Subject: RE: Ford Road Arundel- AB/88/19/PL

Paul Cann
Principal Engineer (Drainage)

Please find attached our revised drainage drawing E19-003-1000A and micro drainage calculations along with structural sketch E19-003-SK2000 showing the support to the raised tanks.

## Site Drainage Plan

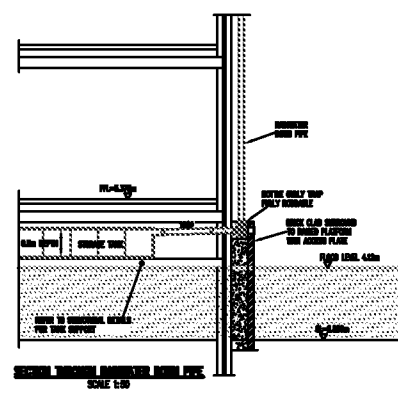
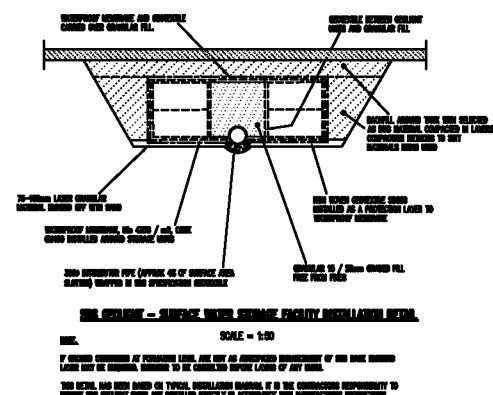
3. Tank beneath building;
 - a) It is noted that the tank has had the orifice removed and now relies on a 150mm outlet, low level hydrobrake and sealed system to operate. The sealed part of the system will need to be very robust. Agreed. Ok

- b) Bolted steel tank sections noted but unclear how it will be possible to unbolt them, particularly any bolts on the upper rim of the tank ie. below floor/void. Yes this needs more detailed consideration with a tank supplier/fabricator. We have also looked at designing a system where the tanks can be lowered to allow access. Access into the voids is very good as the base level is down at 2.8m AOD. The primary members could be designed with a splice in them which would allow a hydraulic winch stacker (similar to that used to install steel beams in buildings), to lower the platform and tank down allowing much better access. This needs some detailed design which would be best conditioned to allow a detailed solution to be sorted. Agreed

- c) Tanks would need to be protected against corrosion both inside and out. Agreed. The tanks will need to be galvanised inside and out along with any steel support structure. Ok

- d) The upstream rodding point is shown on the section but not on the plan. Specify as 300mm diameter pipe. We have amended the plan to show the pipe as 300mm in diameter. Ok

- e) Show tank gradient on section. The tank gradients have been shown on the plan. I can't identify the actual gradient, however, I am happy to leave this to the detailed design. Just be aware that a reasonable fall will be expected.

- e) Access is still considered an issue and needs to be addressed further. My suggestion; In addition to the rodding points, can man entry access be made into each tank? I.e. side entry via hatch with appropriate water tight pressure seals/wheel handle/etc i.e. similar to what you can get on marine vessels. We can look at providing access panels to the sides of all the tanks in conjunction with the notes for item (b) above. Again this needs some detailed design input from a manufacturer/fabricator and as with (b) above could perhaps, be conditioned. Noted, and agree it can be conditioned. The essential thing here is that you are now fully aware that the access needs to be greatly improved and some reasonable ideas have been batted about. It will now come down to the detailed design.
